# CITY OF ALBUQUERQUE

RE: **Mercado el Milagro**  
**10000 Central SW**  
**Conceptual Grading Plan Stamp Date: 9/6/19**  
**Drainage Report Stamp Date: 9/6/19**  
**Hydrology File: L09D042**

Based on the submittal received on 9/9/19 the above-referenced submittal is approved for Site Plan for Building Permit.

SHEET NO:
A1.2
2 OF 14

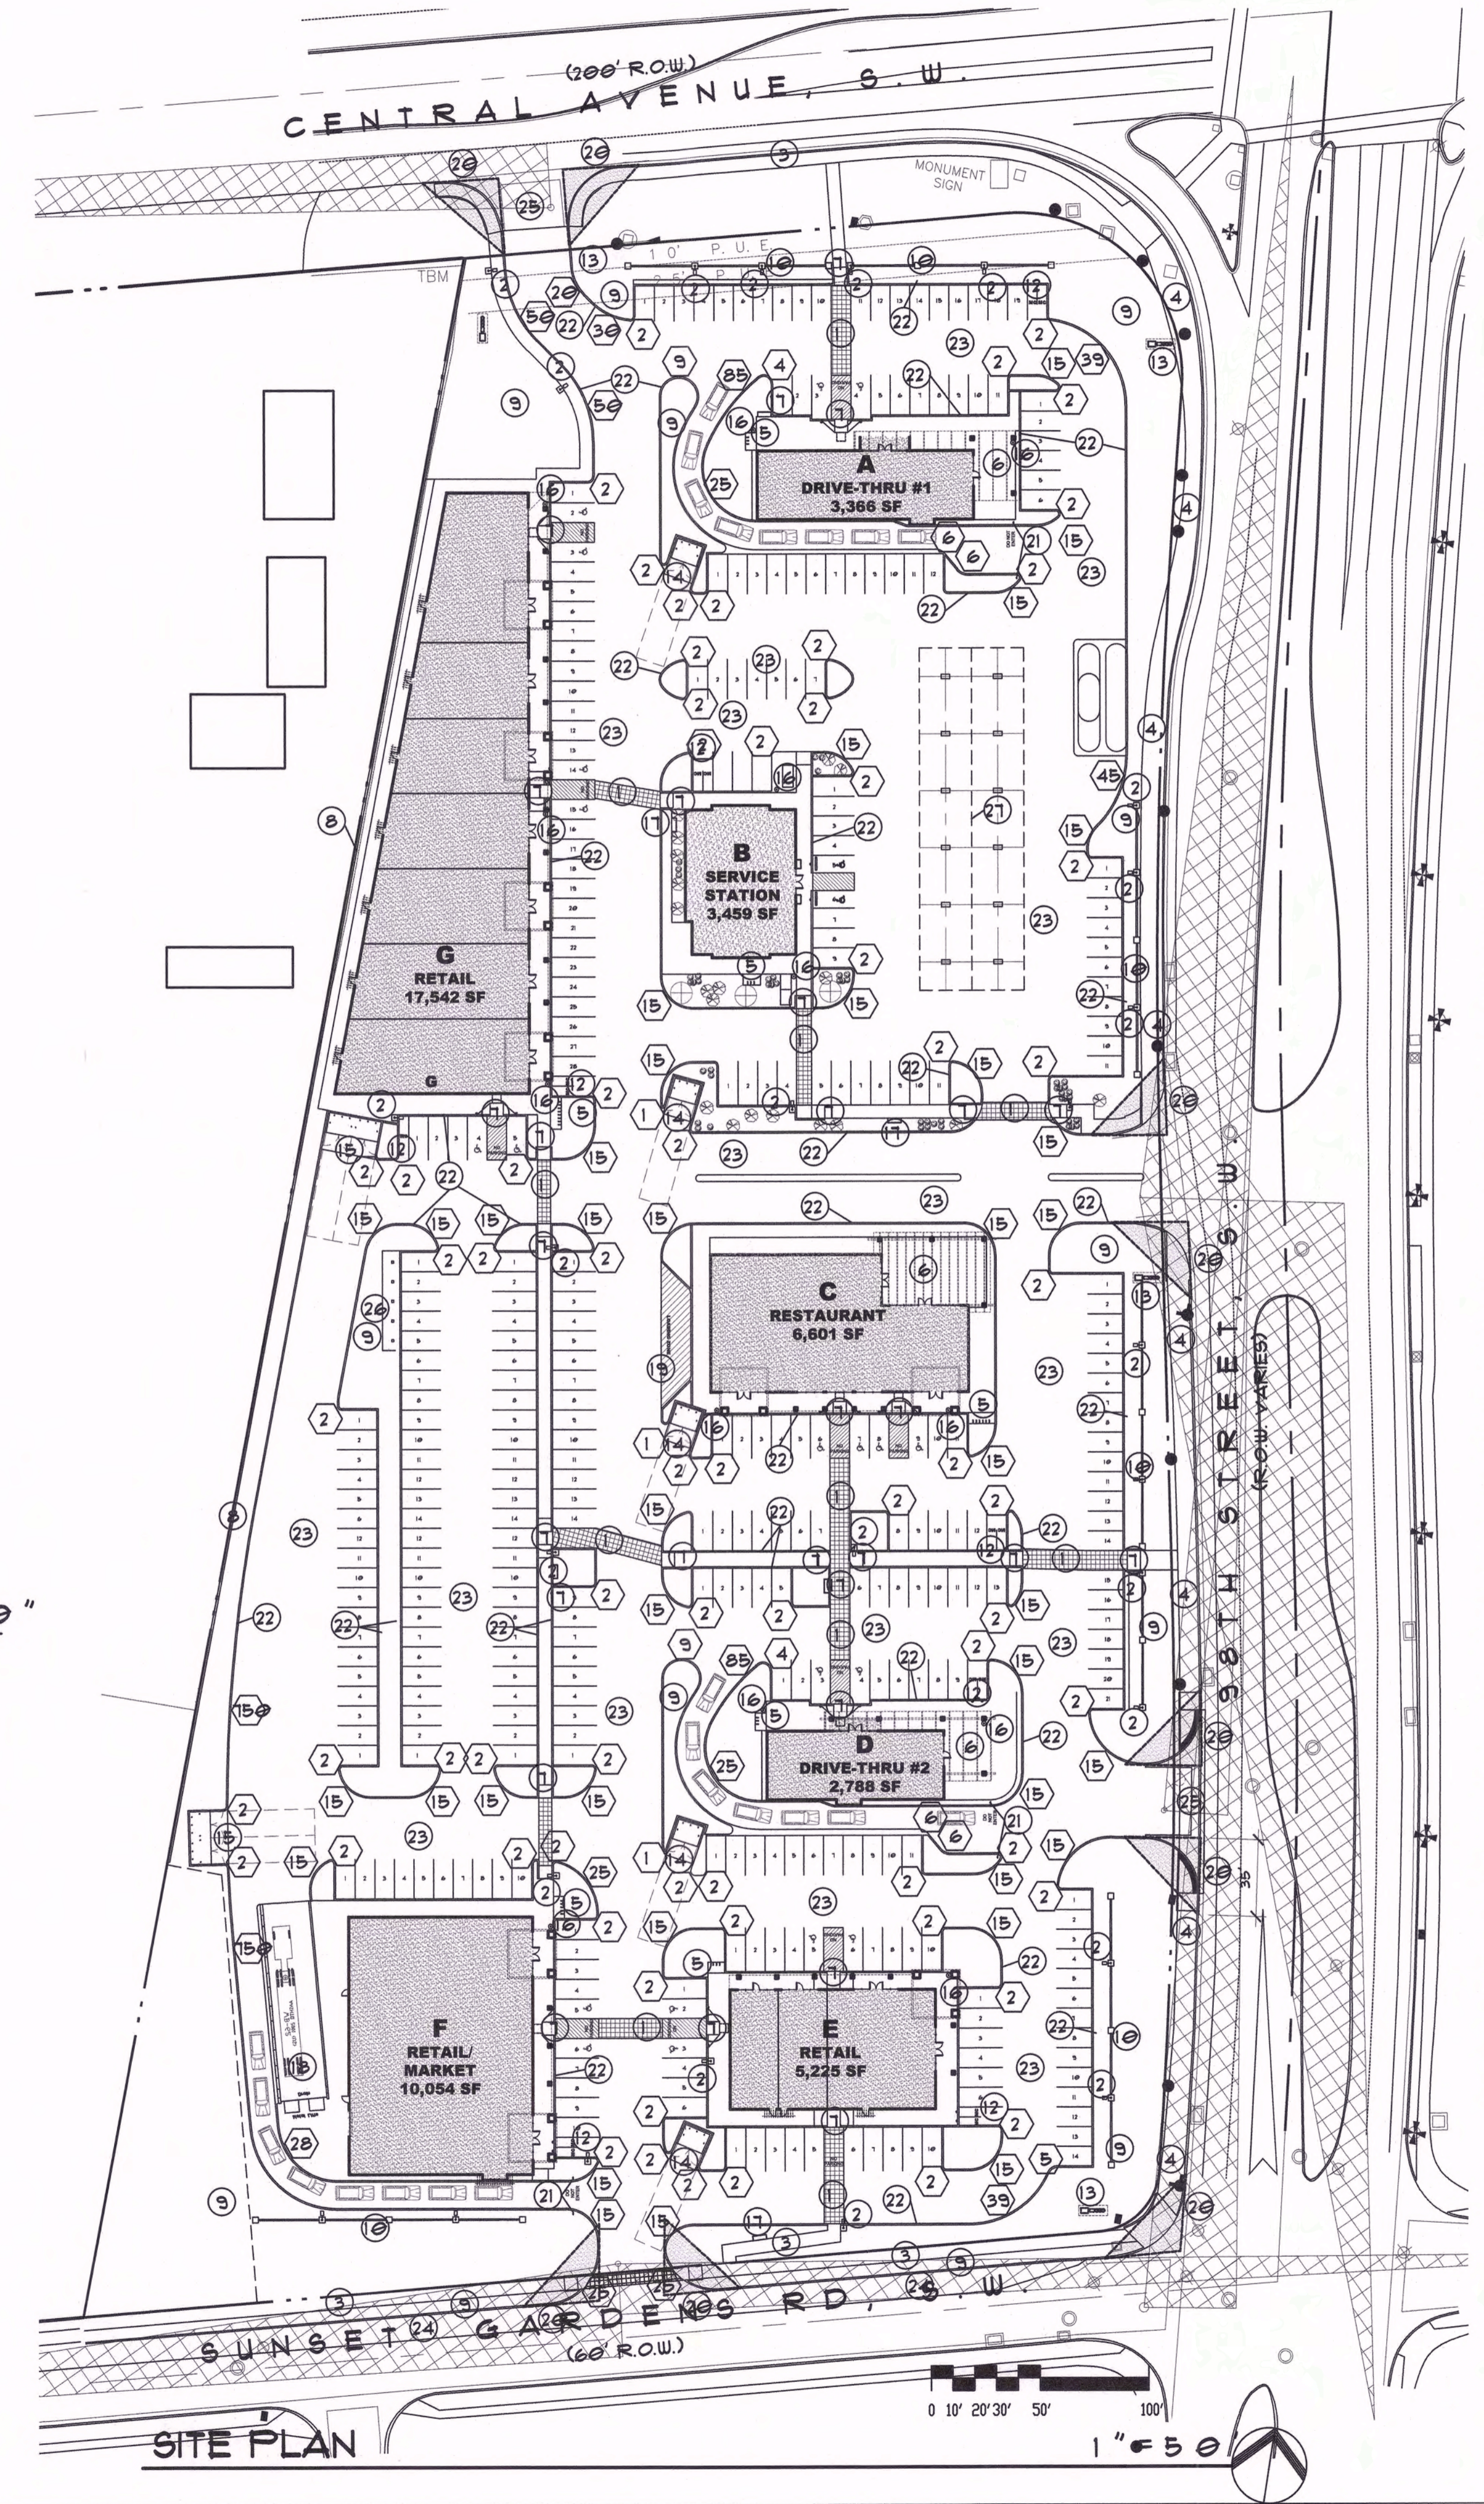
4. For trash enclosures serving food service developments, demonstrate *control of liquids from dumpster areas* per DPM Chapter 22.9.E, Table 1 by containing runoff from the dumpster area and discharging to the sanitary sewer. If this information is on the utility plan please provide it, or show on the grading plan.

CONCEPTUAL GRADING + DRAINAGE PLAN

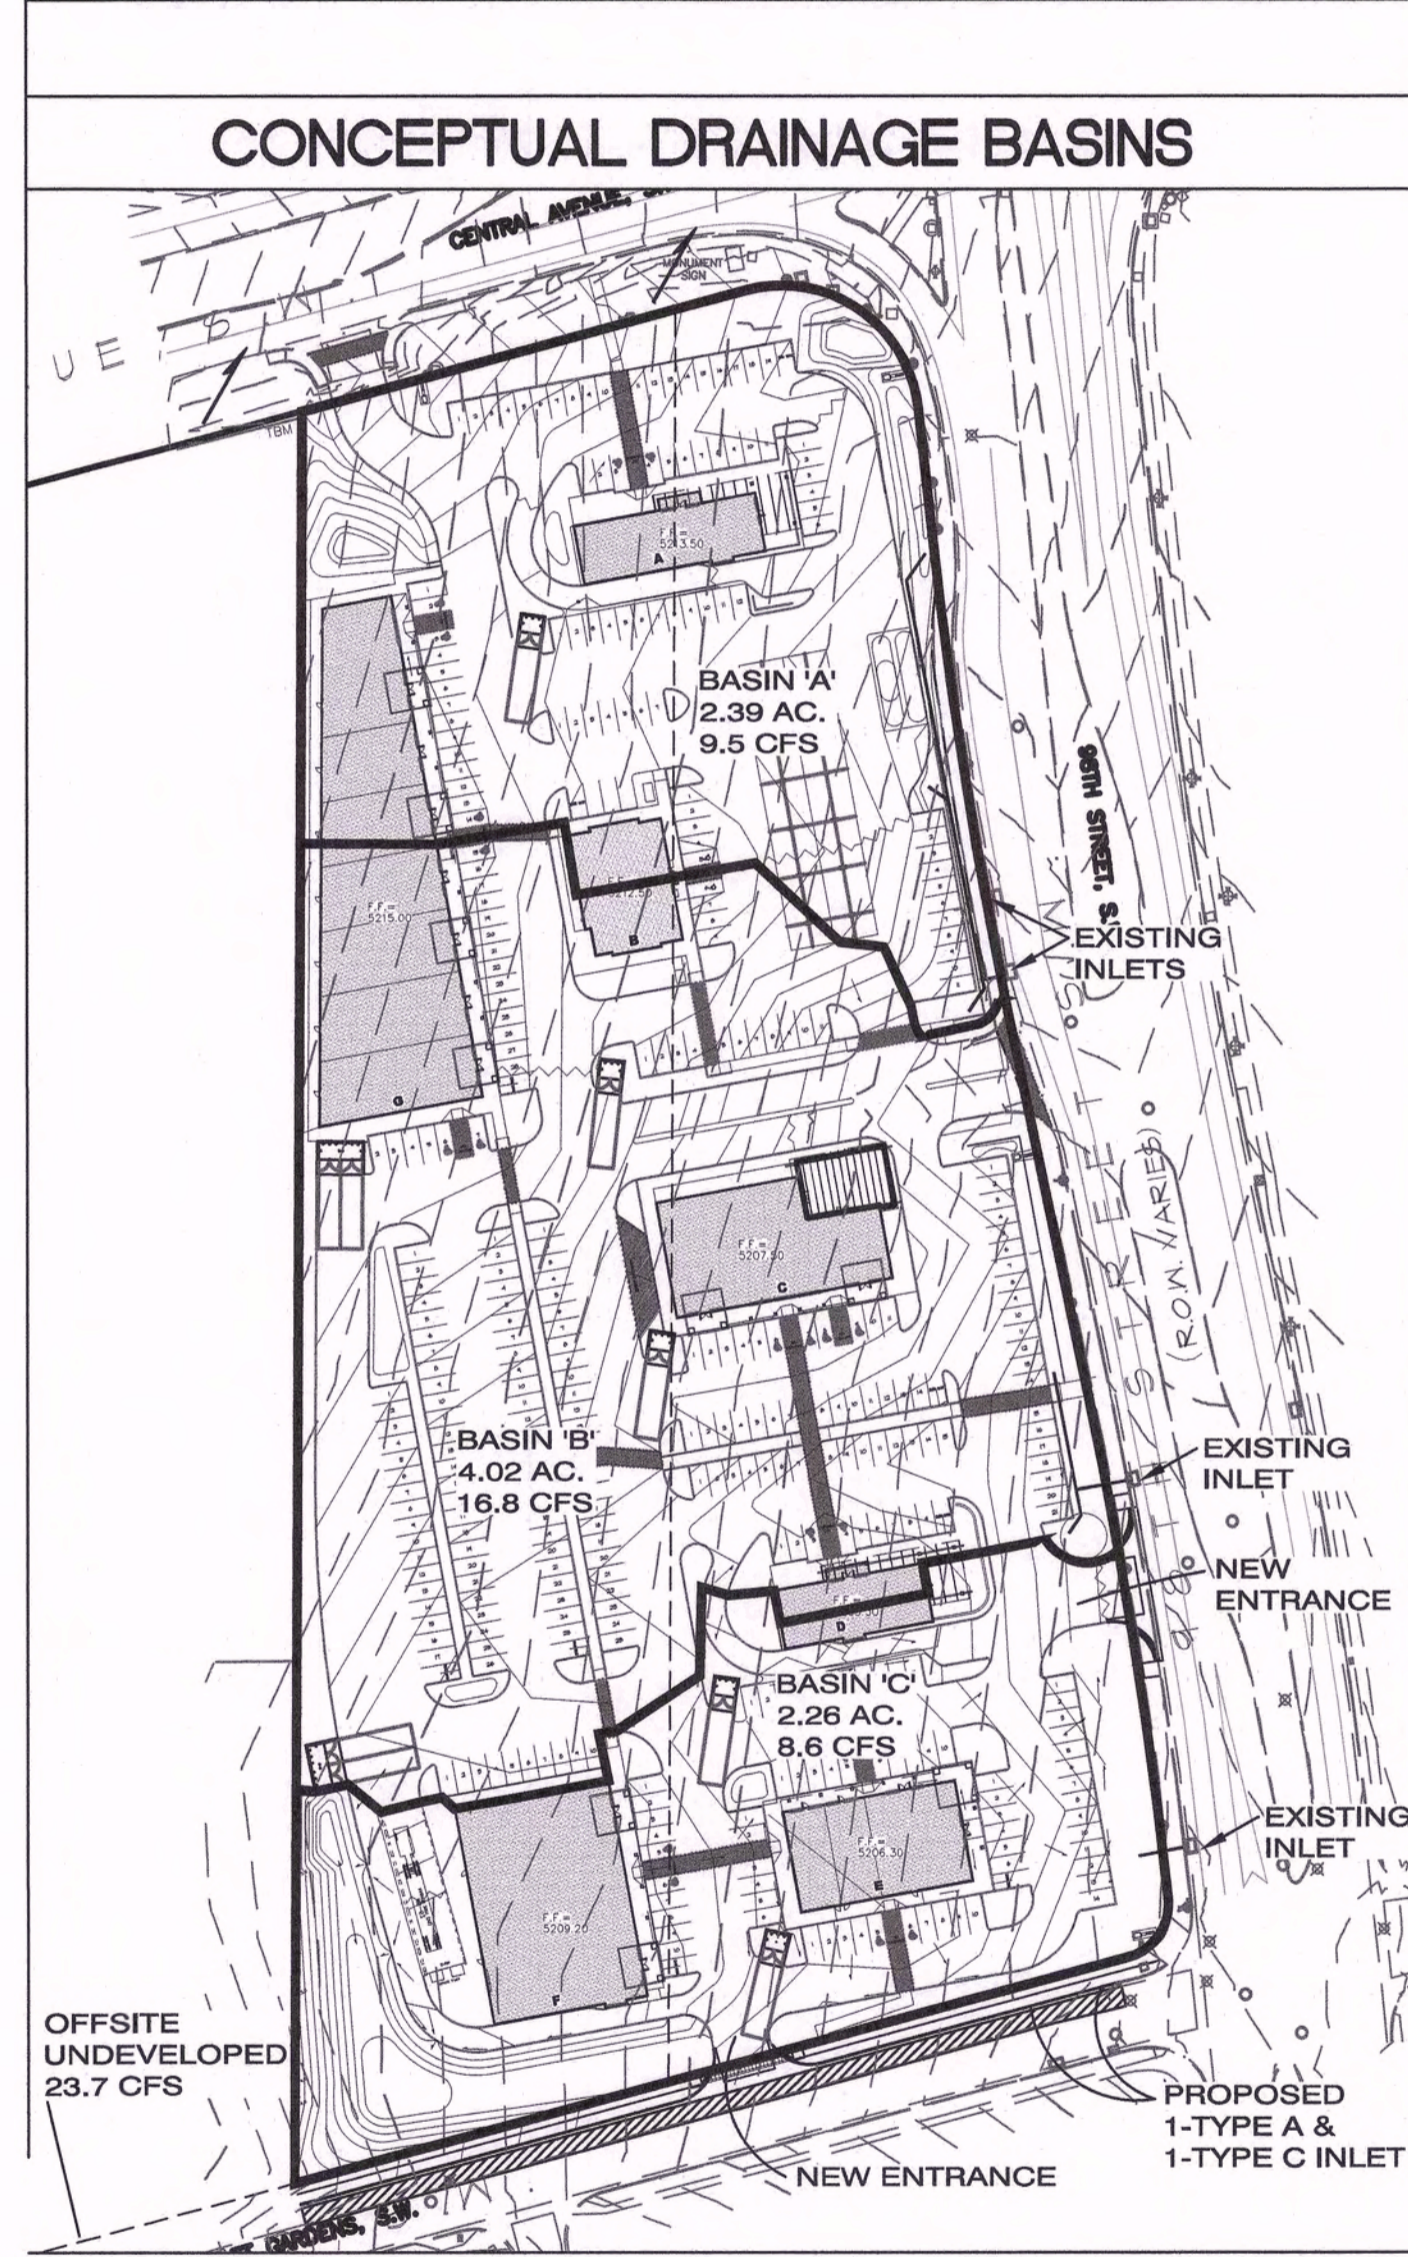
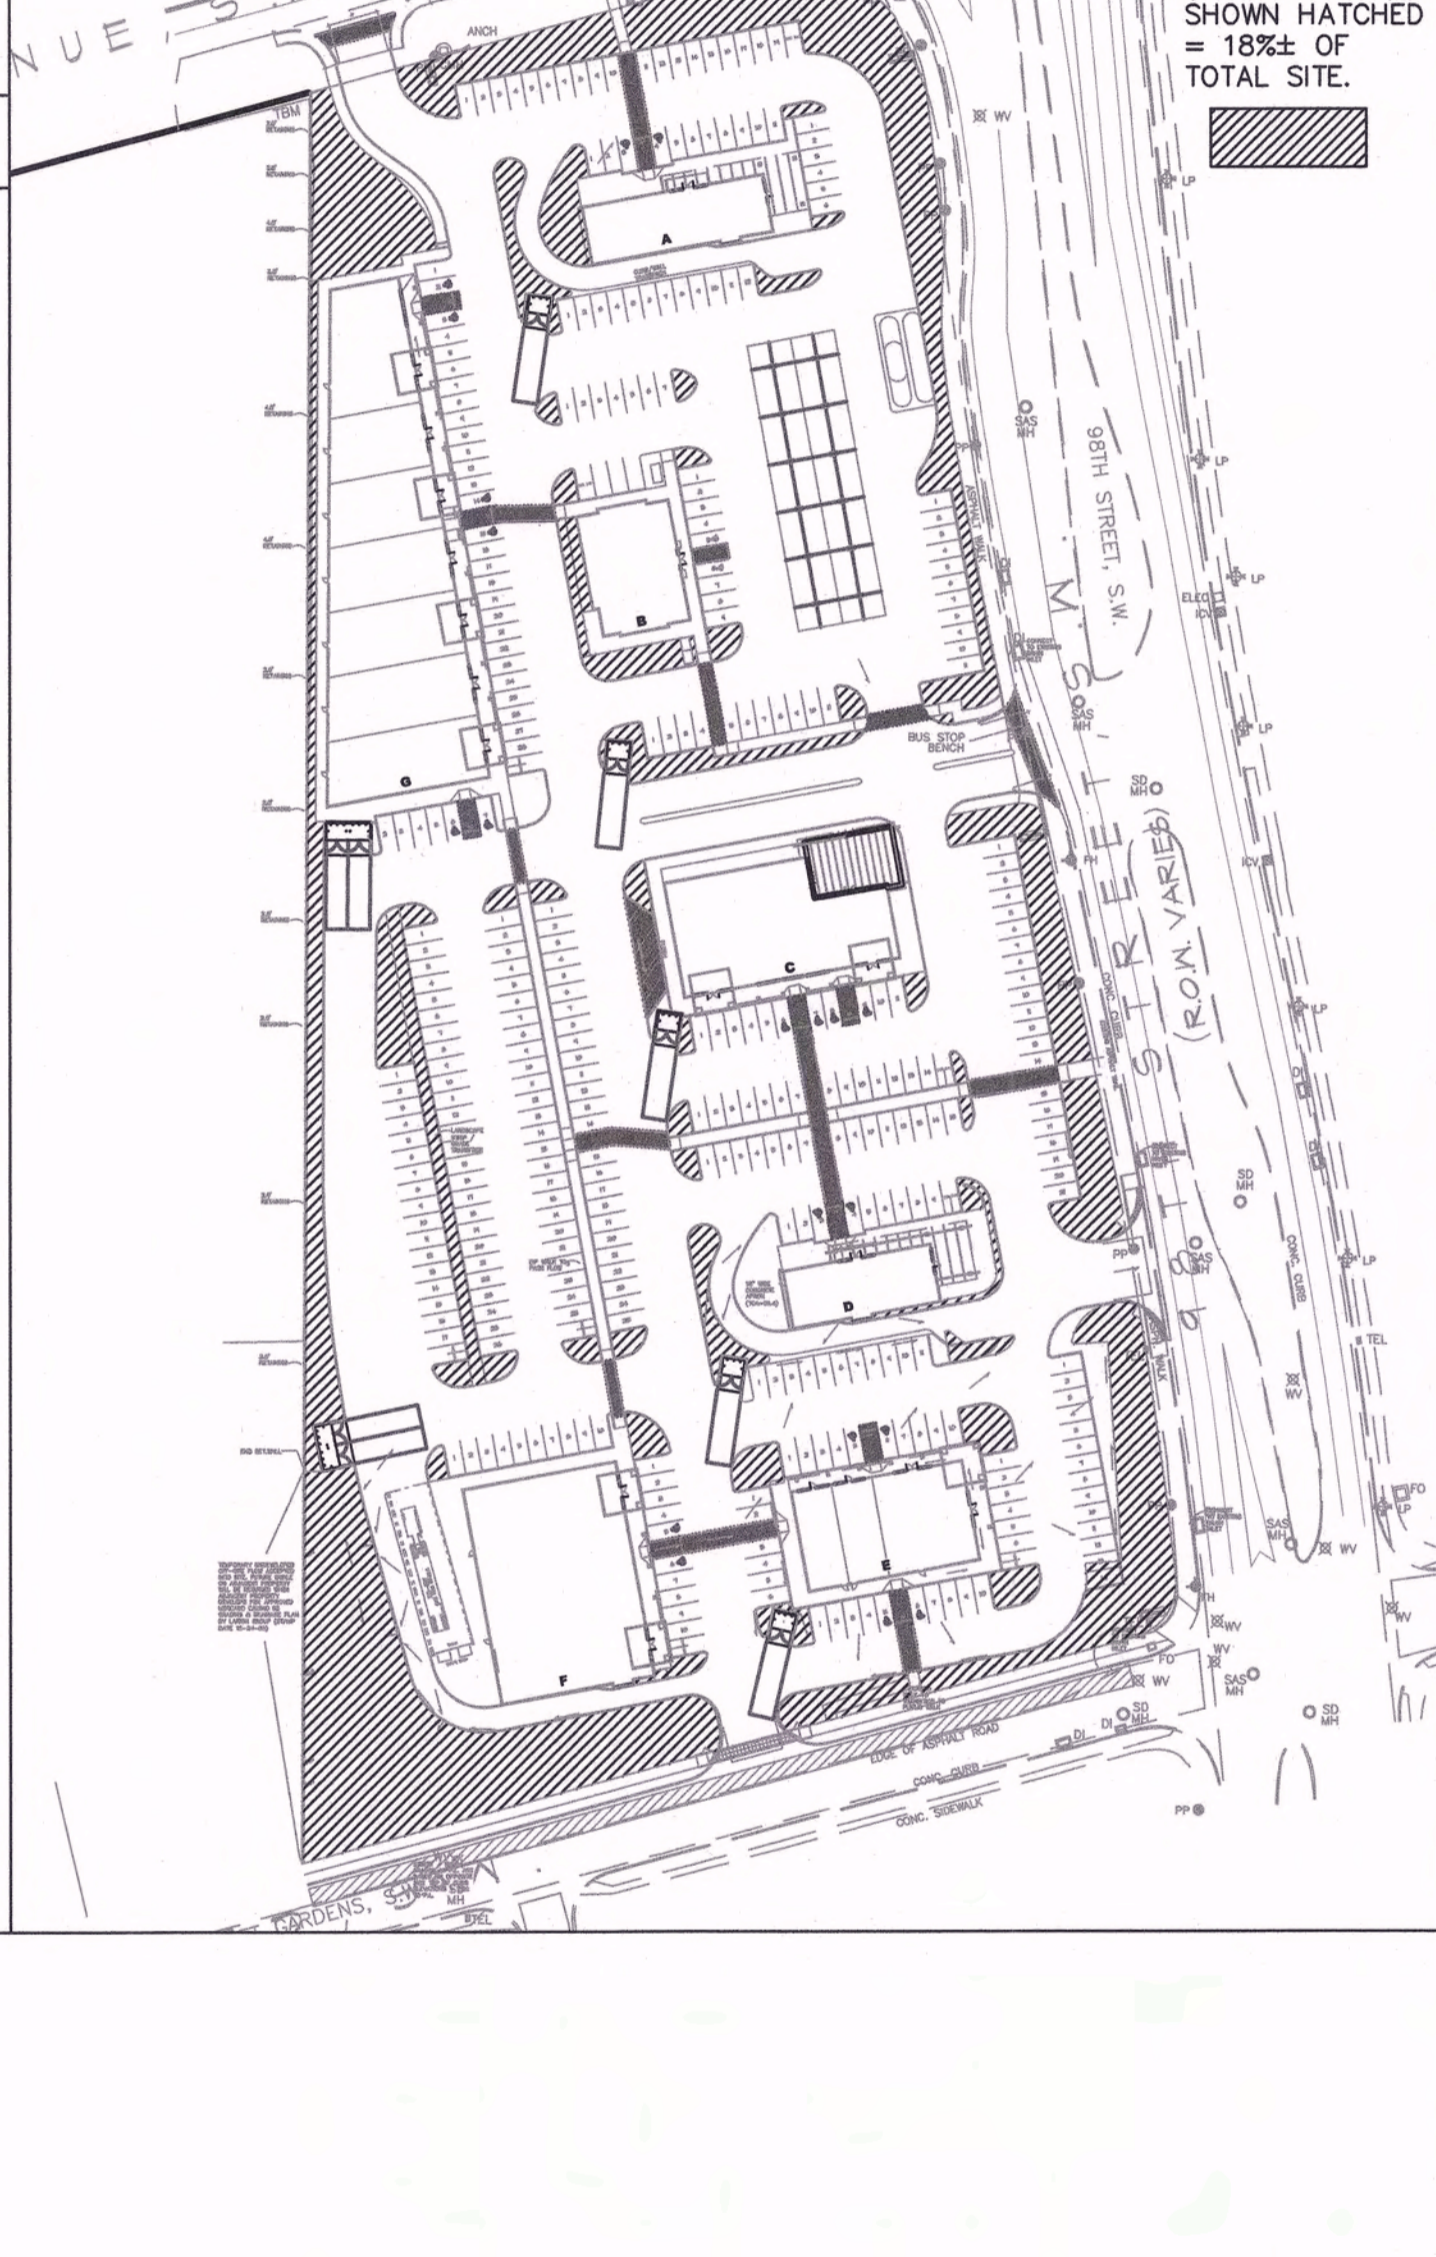
1. Additional detail is required on the retaining wall:
  - a. A structural design for wall with showing how a reversed footer will be built on the property line.

- b. Grades in the adjacent lot, top of wall, and bottom of wall elevations, showing tie-in at property line along the length of the wall.
  - c. A detail of the spillover structure showing how flows will be accepted into this site.

- d. A cross-lot drainage easement is needed for undeveloped flows along the interim condition flow path.
2. Remove all "Conceptual" markings.
3. As a reminder, if the project total area of disturbance (including the staging area and any work within the adjacent Right-of-Way) is 1 acre or more, then an Erosion and Sediment Control (ESC) Plan and Owner's certified Notice of Intent (NOI) is required to be submitted to the Stormwater Quality Engineer (Doug Hughes, PE, [jhughes@cabq.gov](mailto:jhughes@cabq.gov), 924-3420) 14 days prior to any earth disturbance.
